COMMENTS ON SUBMISSIONS DEADLINE 6. PHILIP WATSON

Extinguishment of rights at Tadcaster East CSEC

## **Annex 3F.A.4 Tadcaster CSEC Access Point**

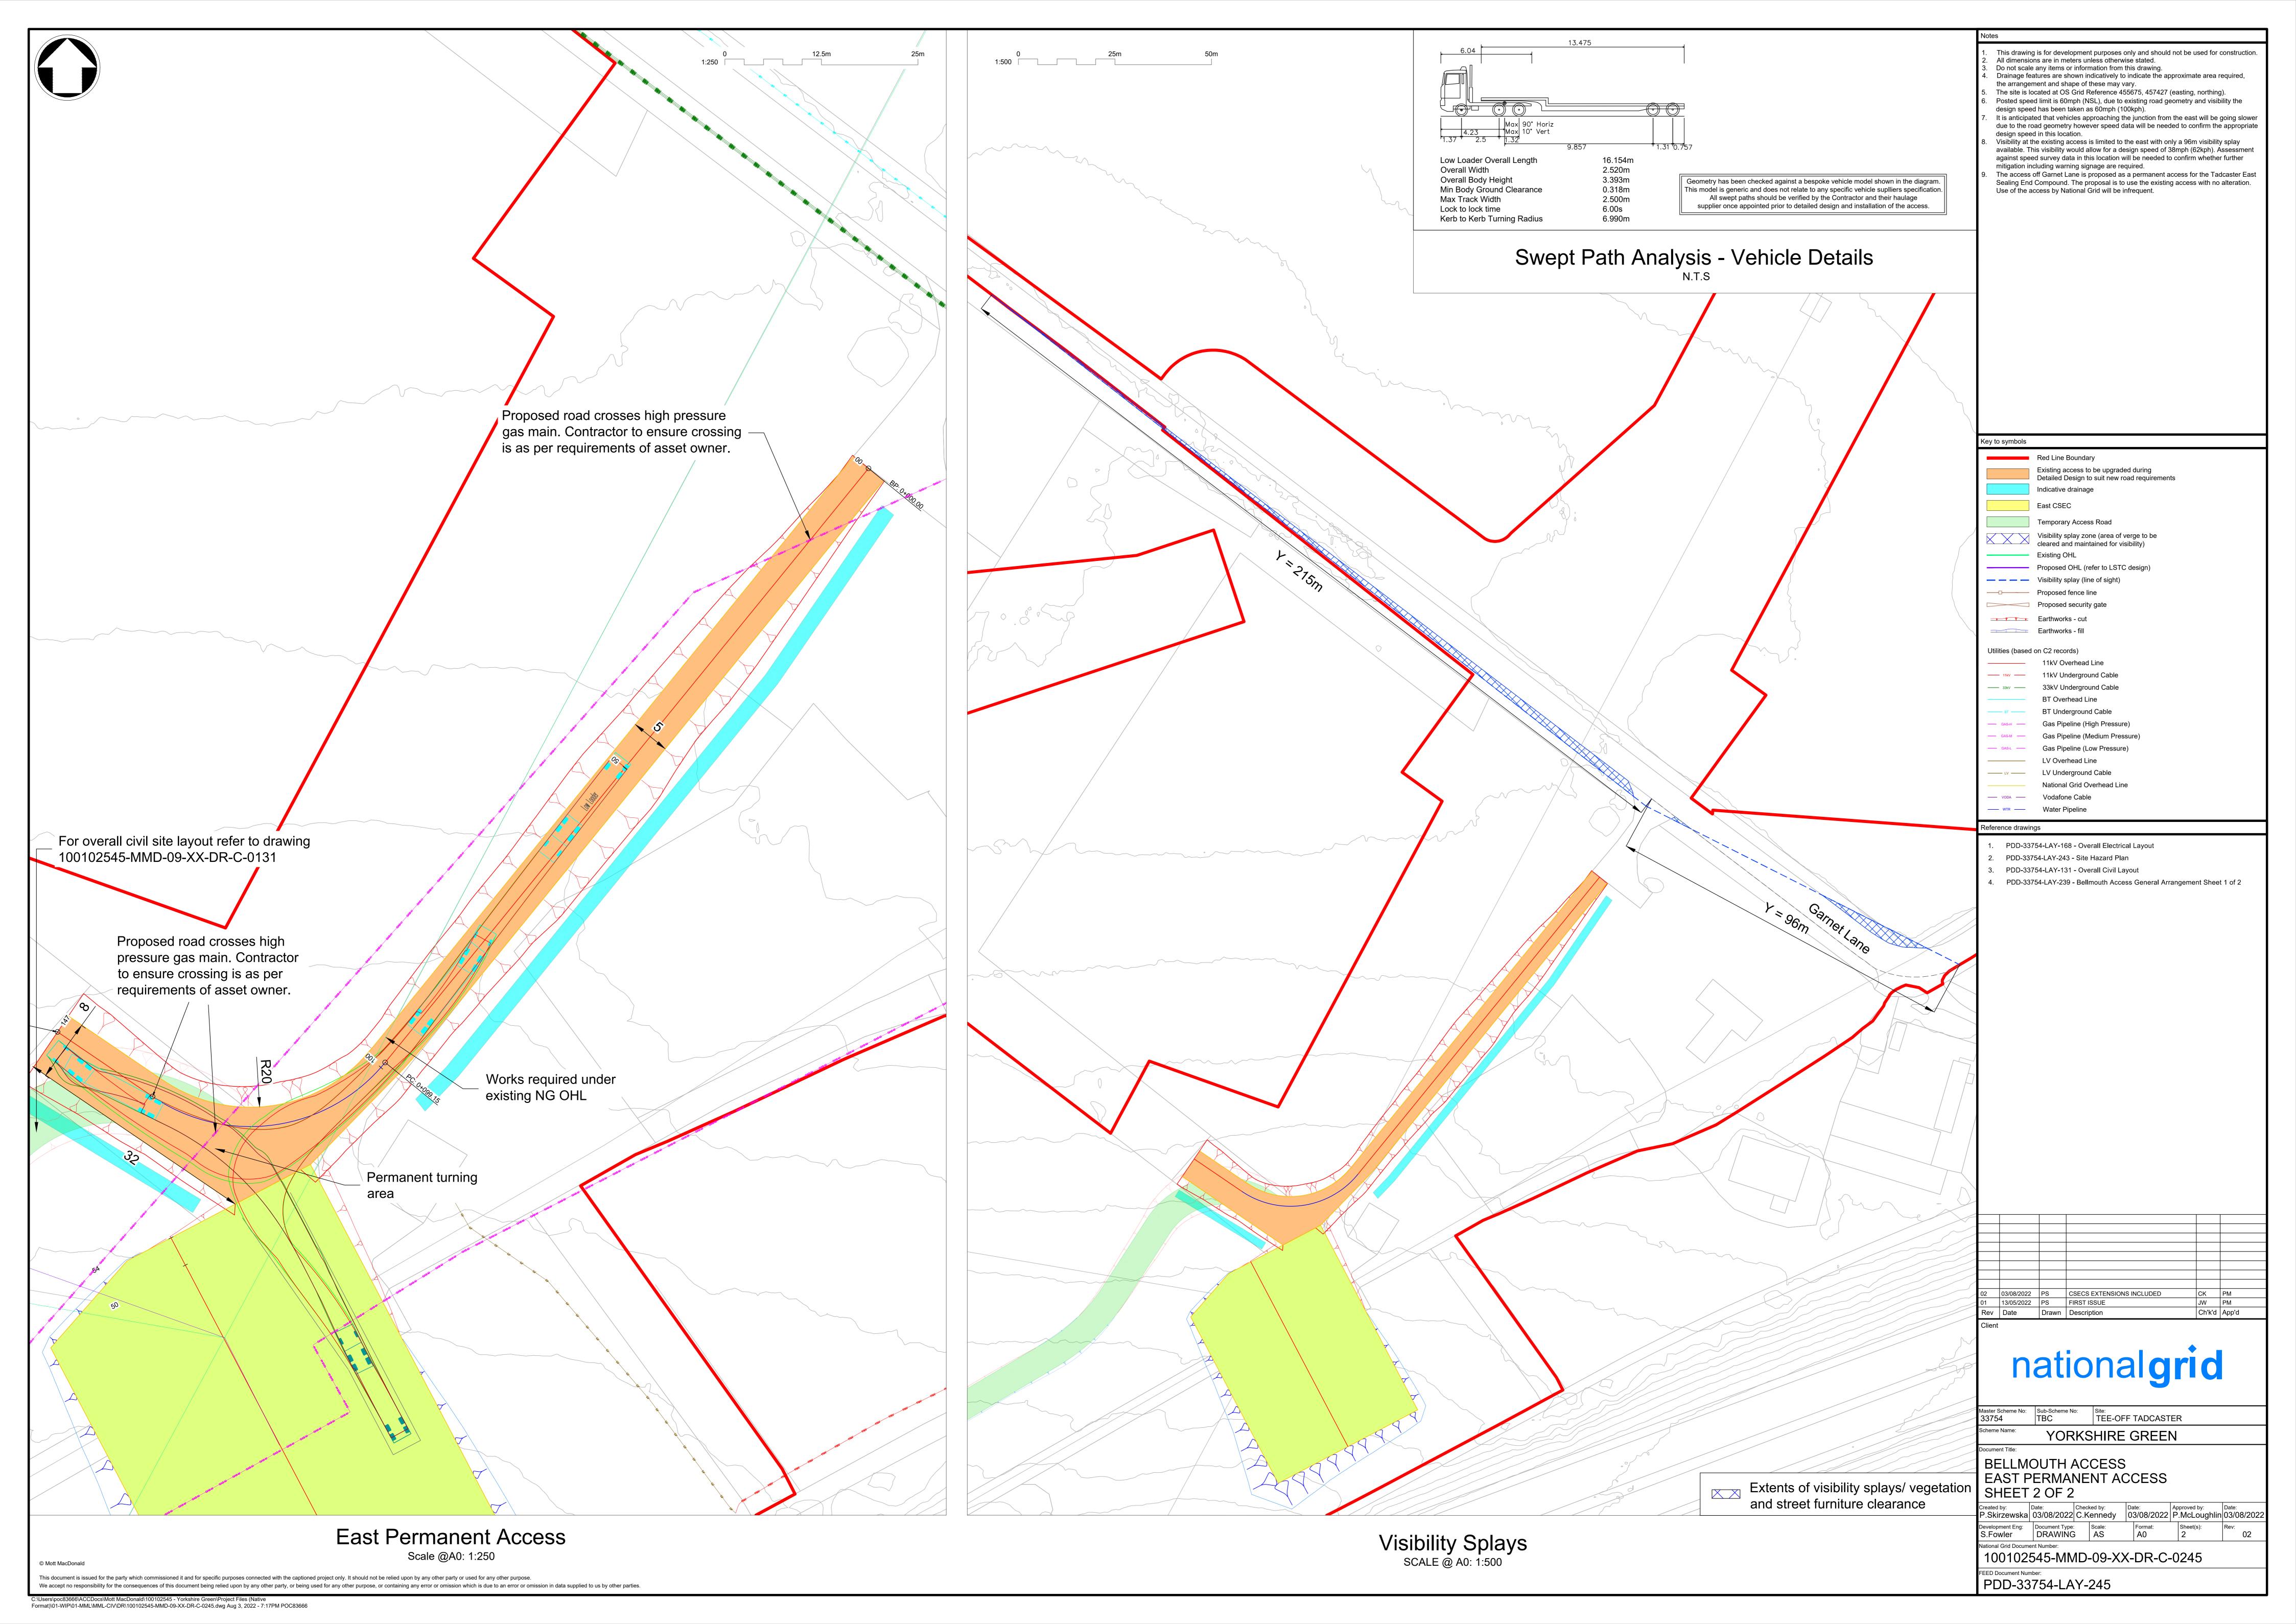
I have recently received some details from National Grid (please see A659 Access- Tadcaster in the file attached). I understood at the CAH2 meeting that National Grid would be happy to reduce the access road into my field from 7 metres to 4 metres but they have clearly failed to do this in the attached plan. The plan still shows a road into my field 7 metres wide. They also said this would have an impact on the bellmouth and the width would be reduced. I don't think it has though. Clearly National Grid have created a parking area large enough for an articulated lorry. It seems very obvious to me that it would be free of any obstructions and any vehicle would be able to park in this area whether it is connected with National Grid or otherwise. We seem to be talking about a bellmouth some 65 metres wide which is 5 times wider than the existing entrance. The wider this area is the more chance there will be of unwanted visitors. National Grid claim that they want to own this land in order to maintain visibility for vehicles exiting the site. They are going to do the complete opposite. Any vehicle can park in the area occupied by the articulated lorry in question and block the view of anyone wishing to leave the site. There is a serious safety issue here if this happens and because it is a 60 MPH road the potential for a serious collision with oncoming traffic due to reduced visibility will be high if any vehicle parks in this area. A no parking sign is hardly going to deter anyone parking here. National Grid clearly recognise this otherwise they would not have suggested bollards in the entrance.

It seems that National Grid have created an area so that any vehicle can park in the area to the right (Leeds side) and access the site. I presume that National Grid are expecting to approach from the Leeds side looking at the plan. However, my farmhouse is situated to the left (Tadcaster side) so I will be accessing the site from the left. I will have to park on the roadside and get out of my car in the road to then unlock the posts. This will be highly dangerous to both myself and other road users. Upon leaving the site I will have to park on the opposite side of the road and cross the road to lock the posts up. It won't simply be a matter of driving in with a tractor and picking up a boulder with the tractor in one movement as I do at the moment.

I am not sure what the solution could be here but I need to maintain my access point in that corner of the field off the A659 without issues and be in sole control of it as I am now. Perhaps National Grid could have a separate access point onto the brewery land to the
